Objection to mixed-use development with in-fill affordable housing at 164-172 and 174-194 William St, Woolloomooloo (“the site”)

Development Application no.: SSD-80211463 (“the project”)

Developer Applicant: William Street Residential Pty Limited (“the developer”)

12 November 2025

Figure 5: Proposed Building Height Comparative to the Height Plane (Breach)

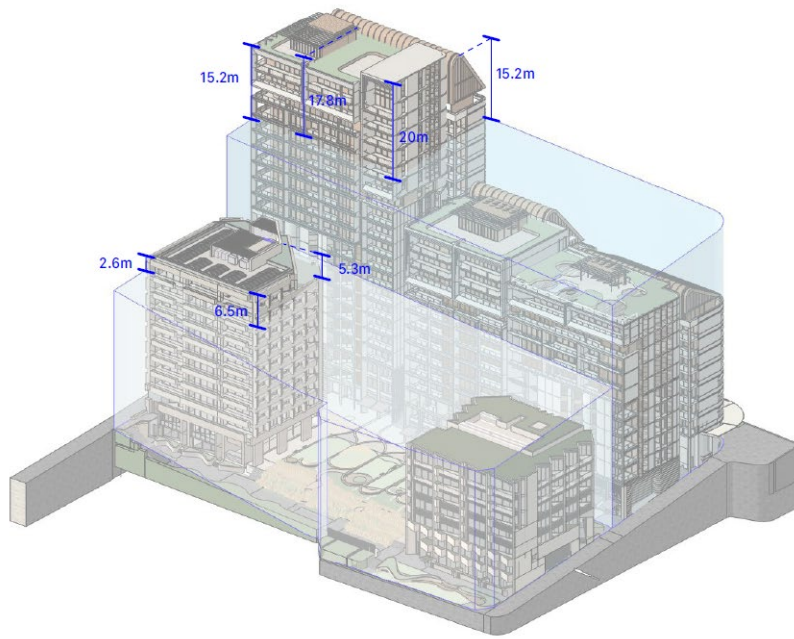
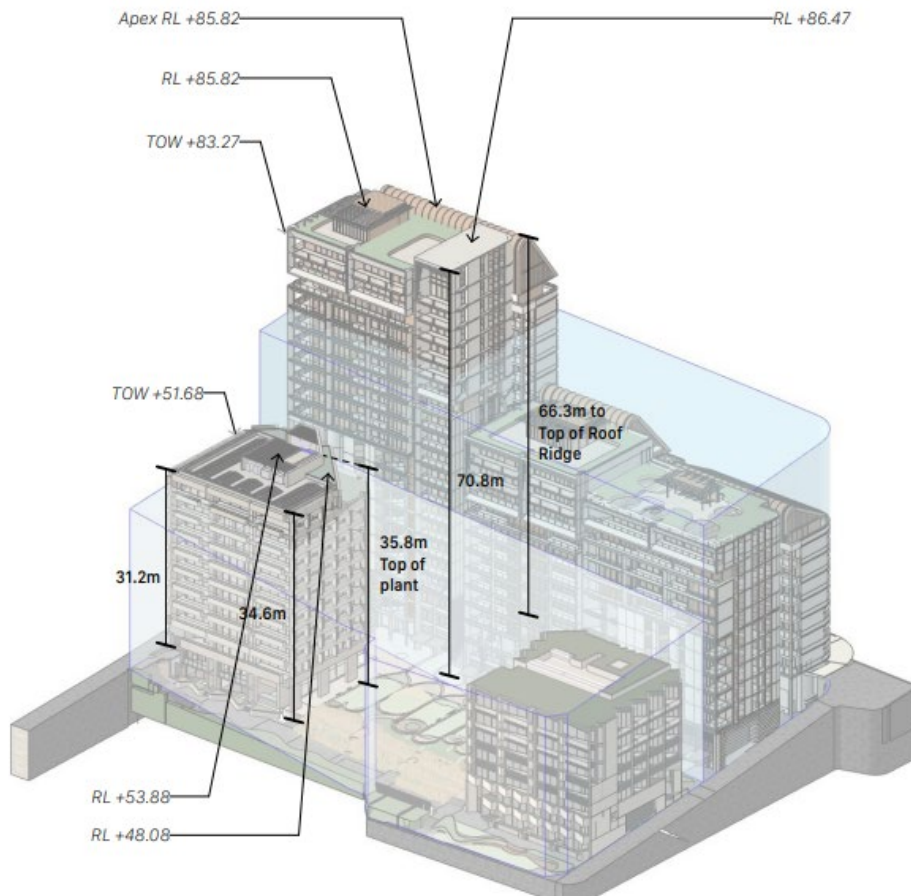
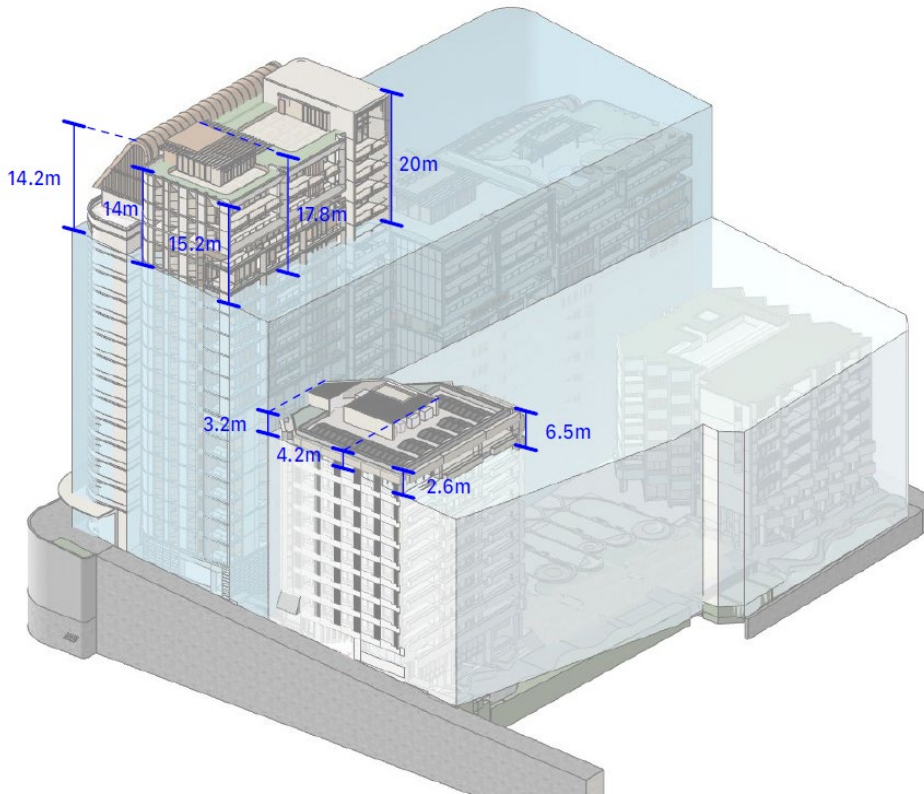
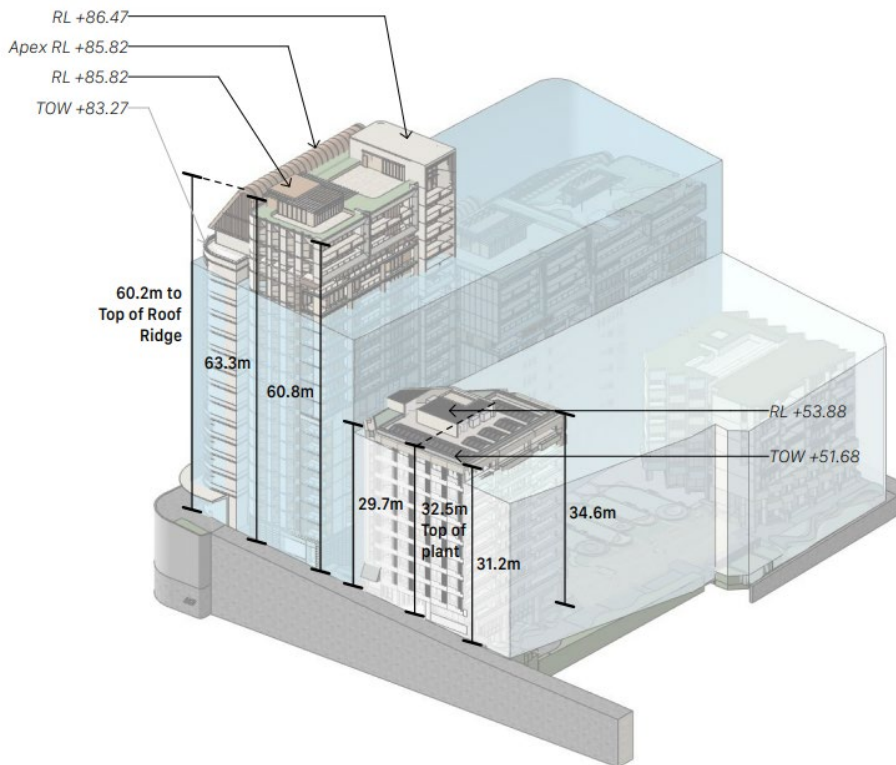
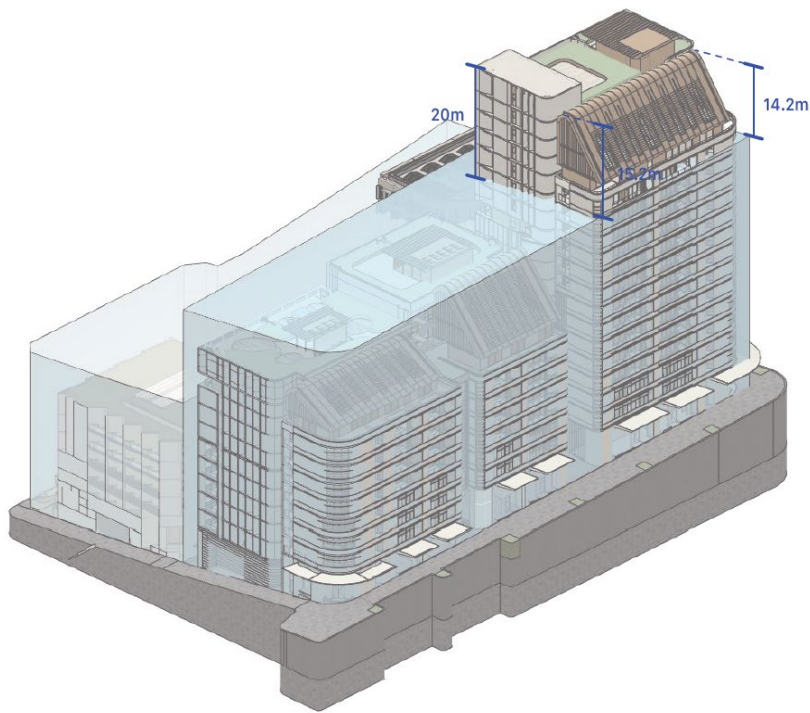
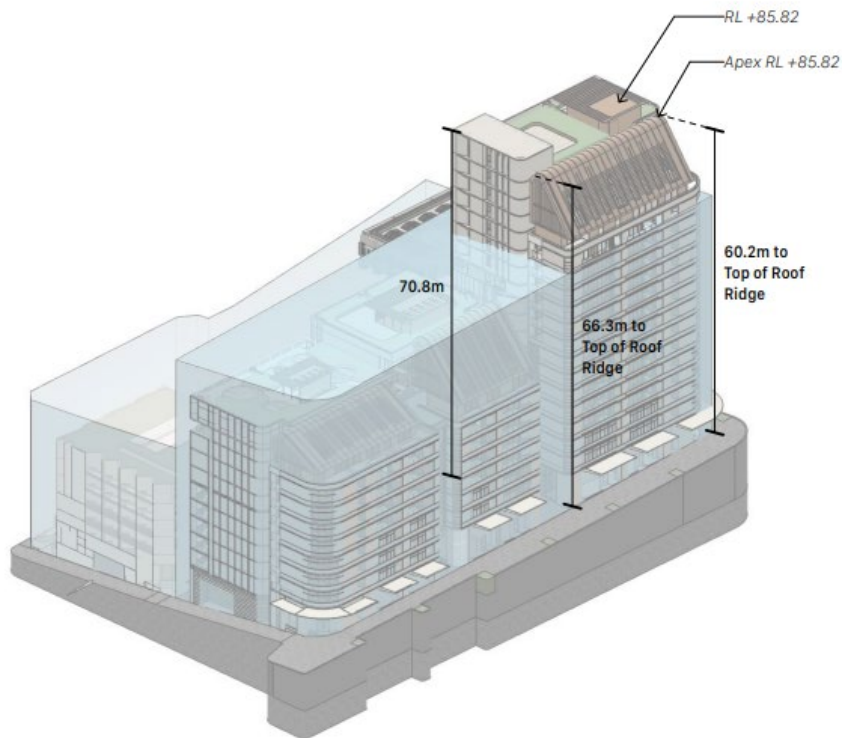
that the height of three of the frontages of the developer’s proposed 18 storey building (situated on the William St-facing southern side of the site) exceeds these assumed 30% uplift maximum heights of 28.6m and 45.5m, as follows, in a table Urbis has prepared and the relevant part of which I have reproduced below:

Building	Element	RL	Height in metres	Breach
Southeast Building (William Street)	William Street frontage (top of roof ridge)	RL85.82	66.3m	15.2m
“	Internal Park frontage	RL86.47	70.8m	20m
“	Northeastern corner	RL85.82	60.2	14.2m

In each case in the Urbis table reproduced above, the asserted extent of the breach of the theoretical “SLEP plus 30% uplift” height limit for the site, appears to be materially understated. For example, the developer’s proposed height of 70.8 metres for the ‘Internal Park Frontage’ of the 18 storey building is asserted to exceed the theoretical “SLEP plus 30% uplift” height limit of 45.5 metres for that part of the site by 20 metres.

That calculation by Urbis, on the figures it provides, appears to be materially incorrect. The correct position, based on the above figures, is that the ‘Internal Park Frontage’ of the 18 storey building would exceed the theoretical “SLEP plus 30% uplift” height limit by 25.3 metres (70.8m less 45.5 metres = 25.3m), amounting to an erroneous understatement of the breach by a further 5.3 metres. This proposed height of 70.8 metres also exceeds the current Sydney Local Environmental Plan 2012 height limit of 35 metres for that part of the site **by an extraordinary 35.6 metres**.

Despite the heading (as set out in italics above) in section 6 of the Urbis Height Report on page 9 referring to a percentage measurement of the extent of the height breaches, in fact Urbis does not provide any percentage figures in section 6 for the variation between the proposal and the “SLEP plus 30% uplift” assumption for the site, let alone for its variation from the Sydney Local Environmental Plan 2012 height limits that currently apply to the site.
